Hunter Transmission Project Environmental Impact Statement (SSI-70610456)

Thank you for your request via the NSW Planning Portal dated 22 August 2025 to the Conservation Programs, Heritage and Regulation Group (CPHR) of the NSW Department of Climate Change, Energy, the Environment and Water (NSW DCCEEW) inviting comments on the Environmental Impact Statement (EIS) for the Hunter Transmission Project (HTP).

CPHR has reviewed the EIS and Biodiversity Development Assessment Report (BDAR). CPHR's review is provided in **Attachment A**.

Figure 14.7a
Field survey locations
Page 24 of 61

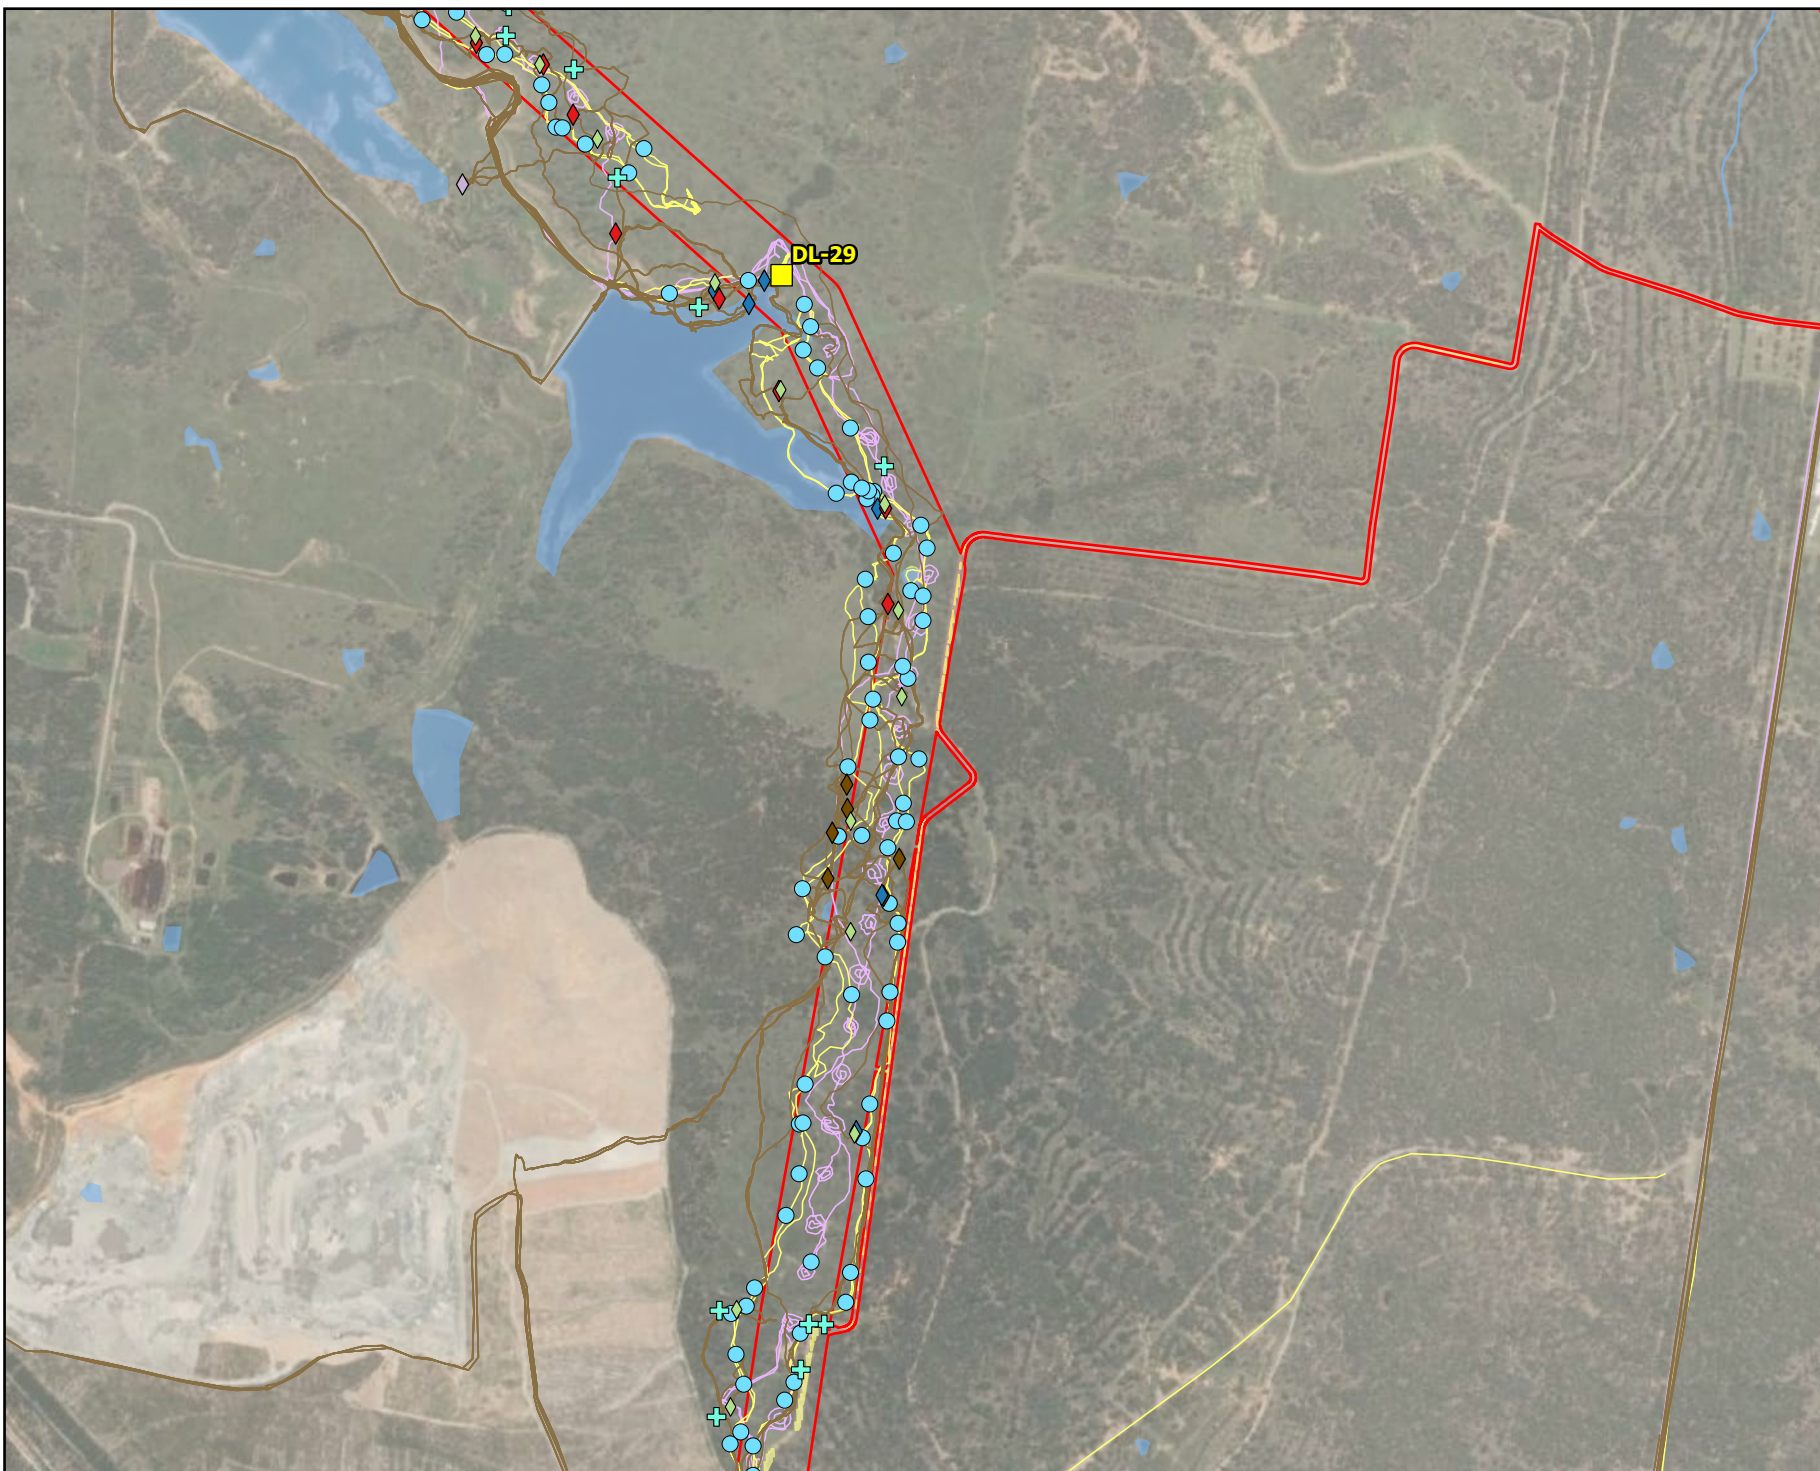
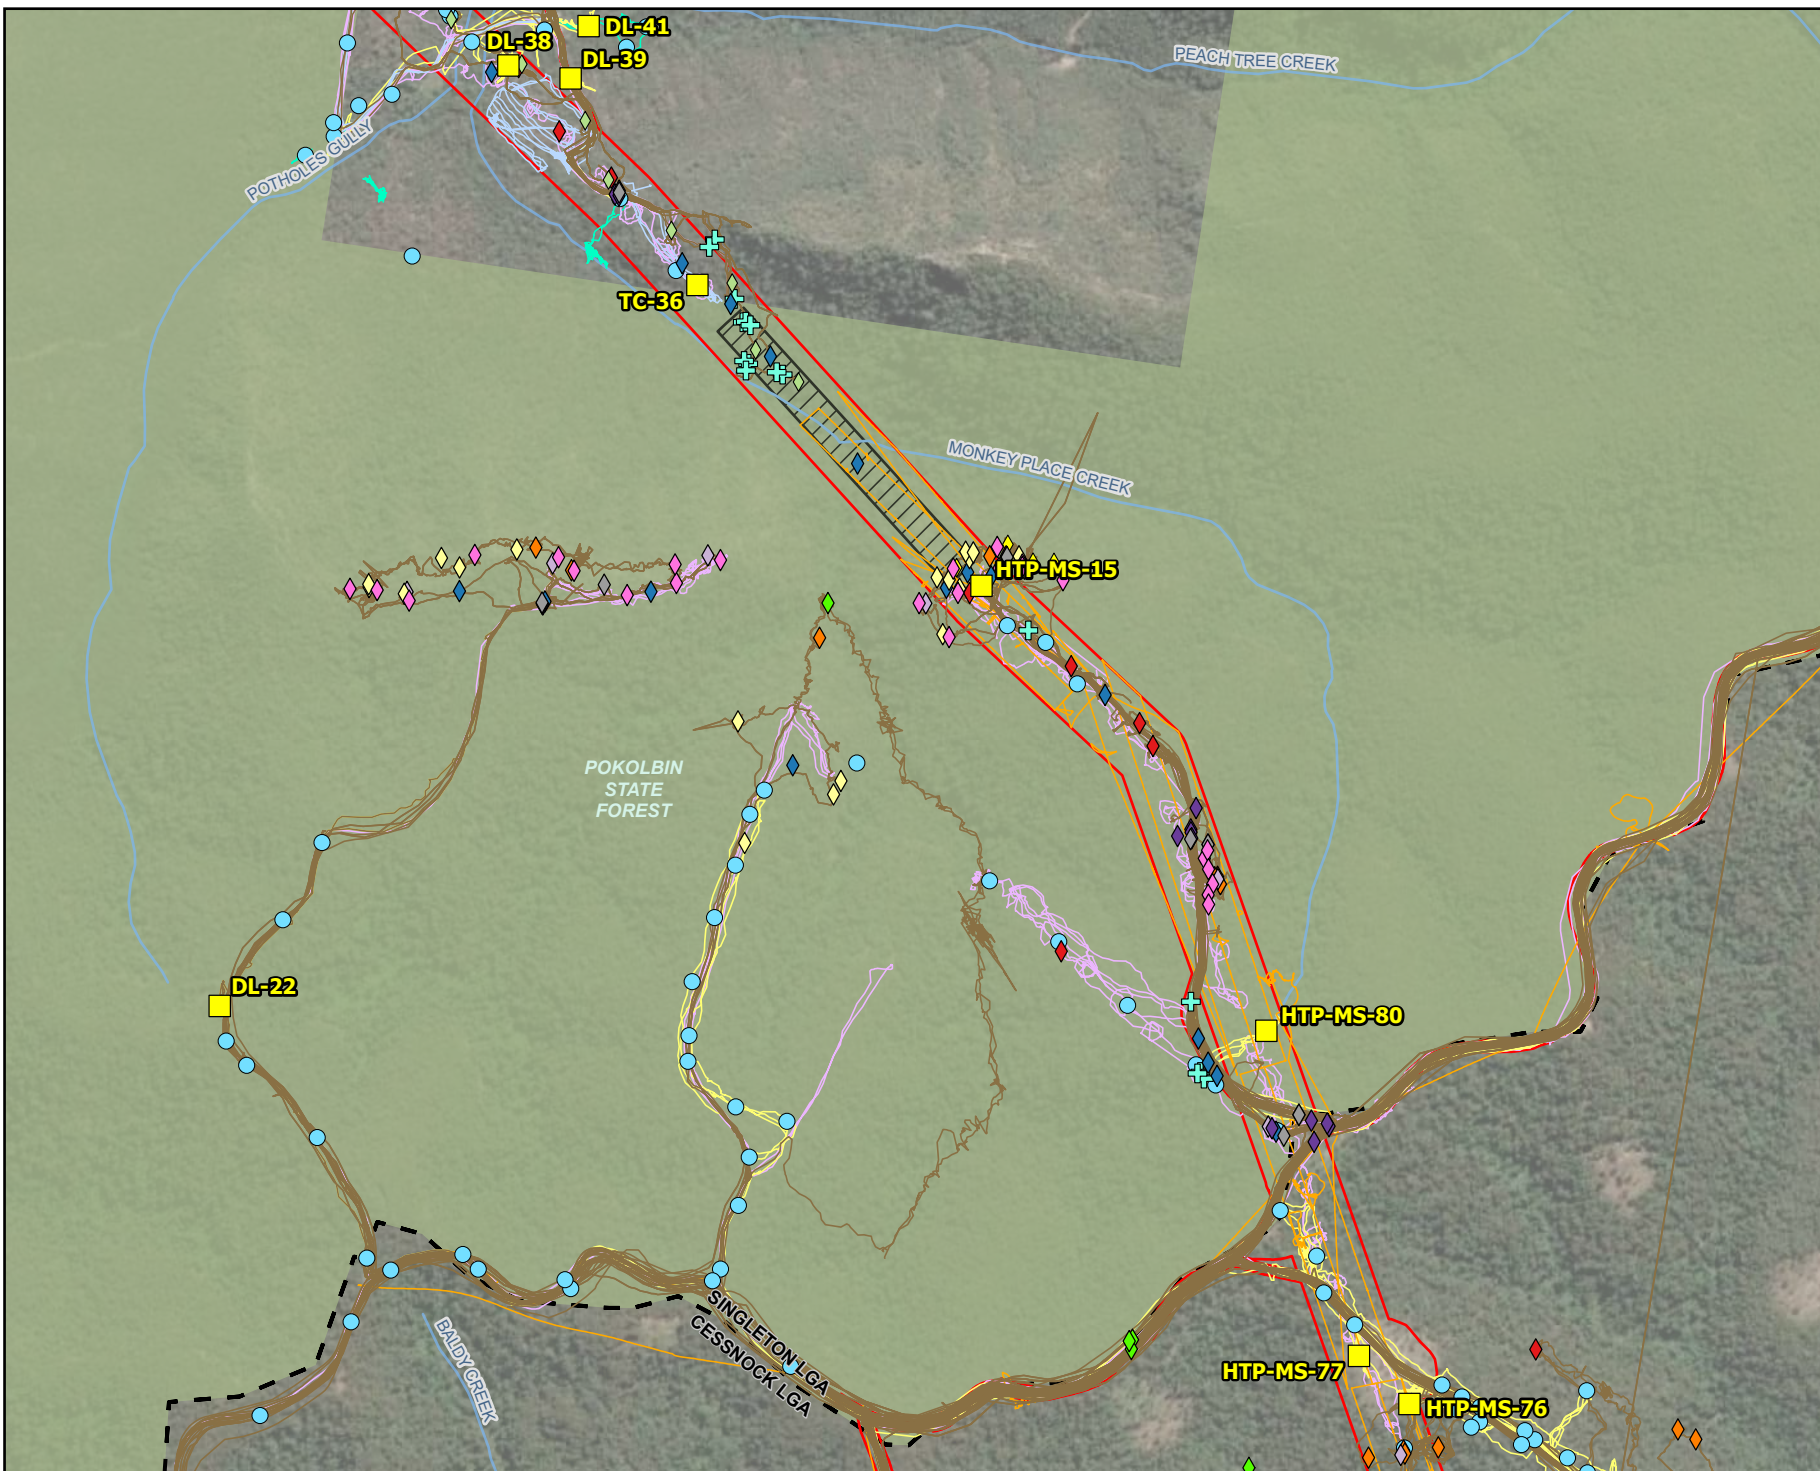
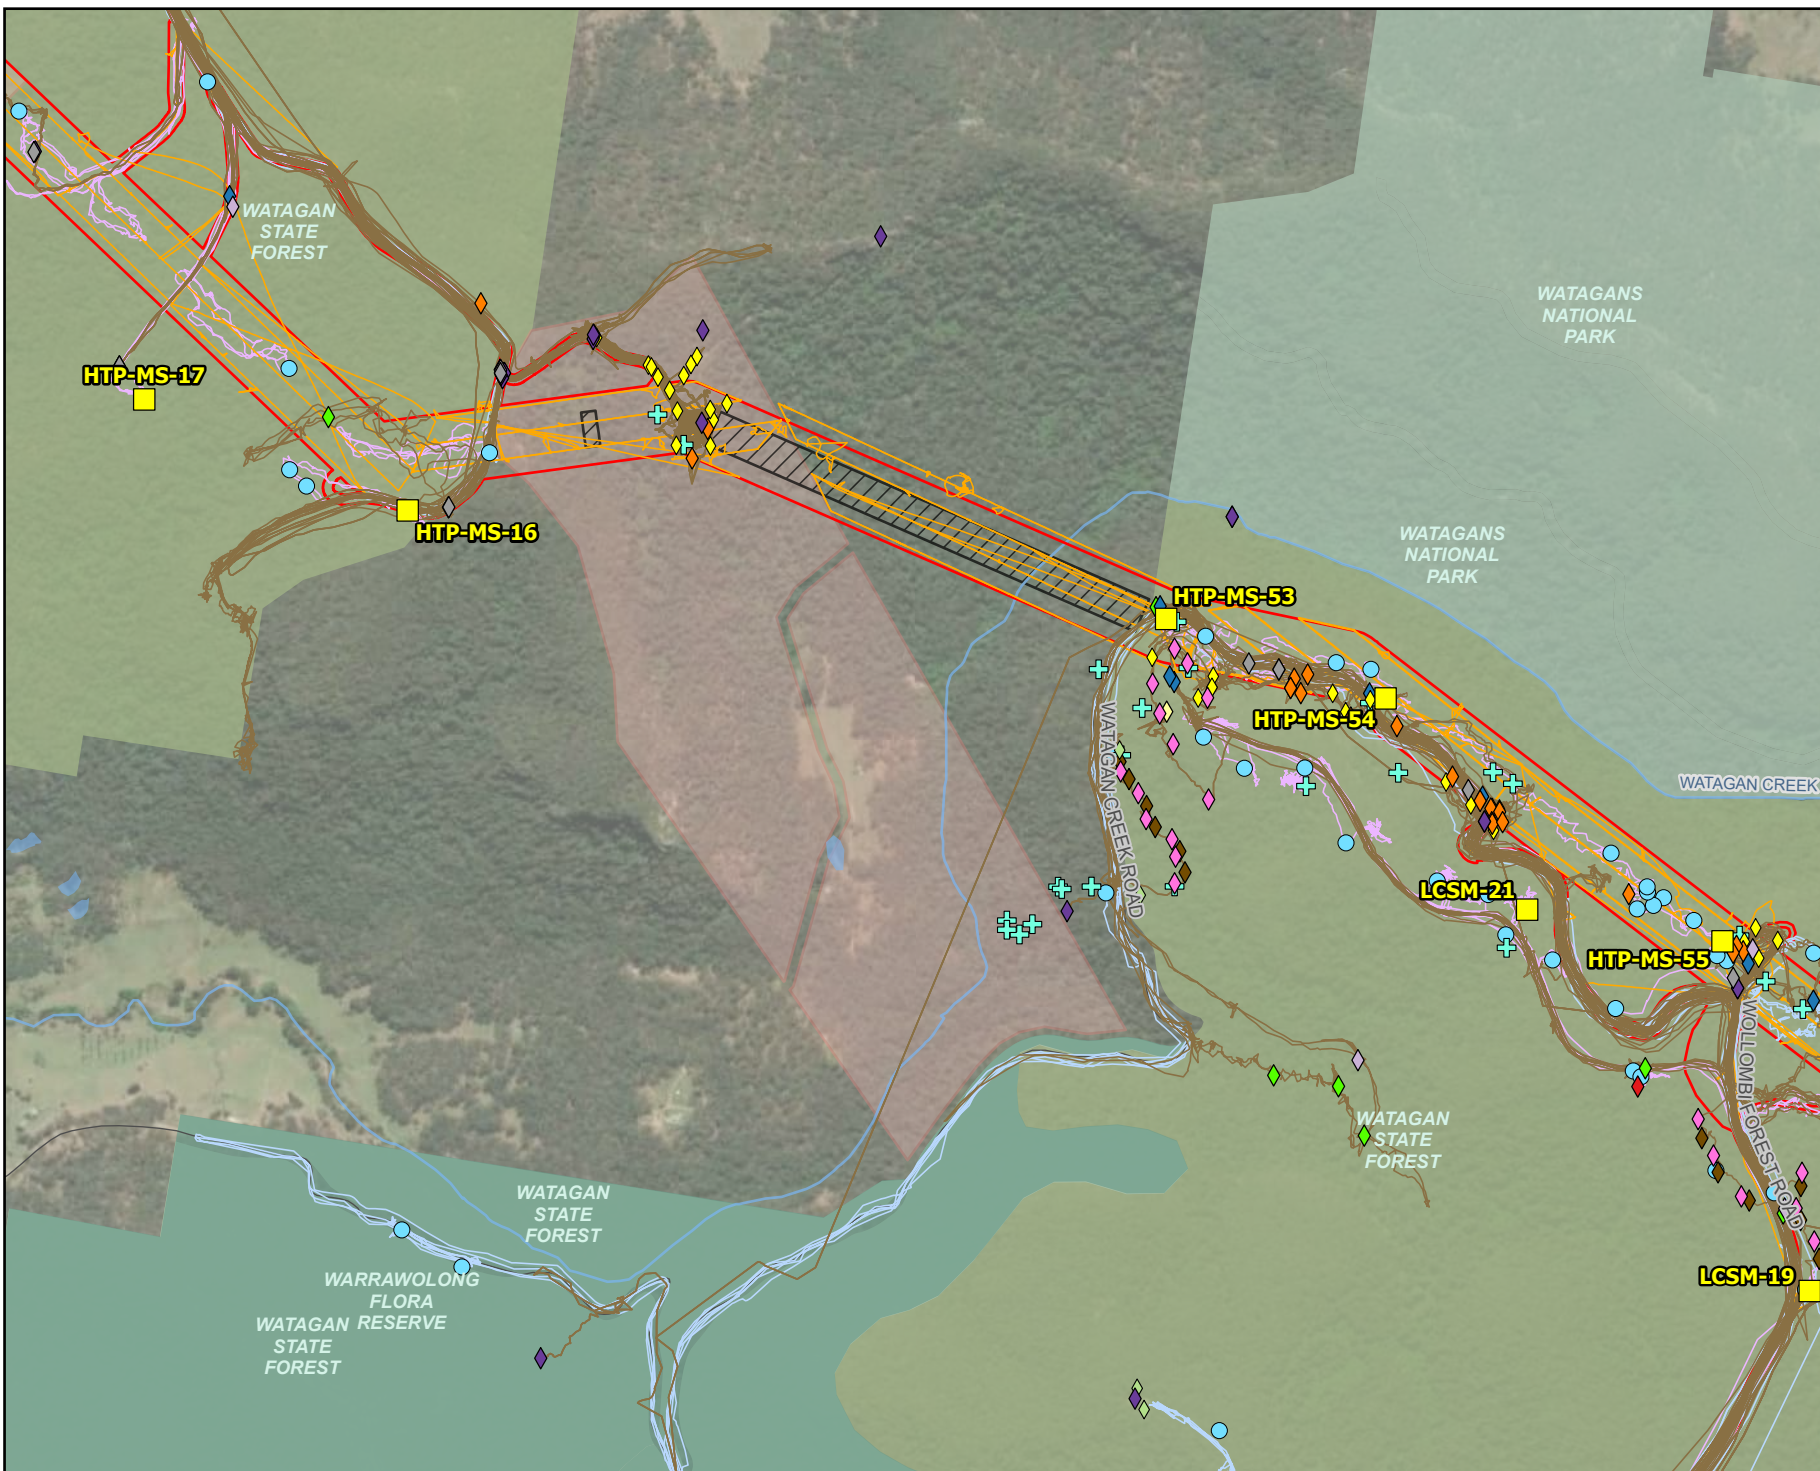
- Provide explanation of approvals used to exclude land (Figure 14.6 in the BDAR).
- Areas mapped as Category 2 land on the transitional NVR Map should be assessed and included in the BDAR unless there is further explanation (see Figure 3 below).
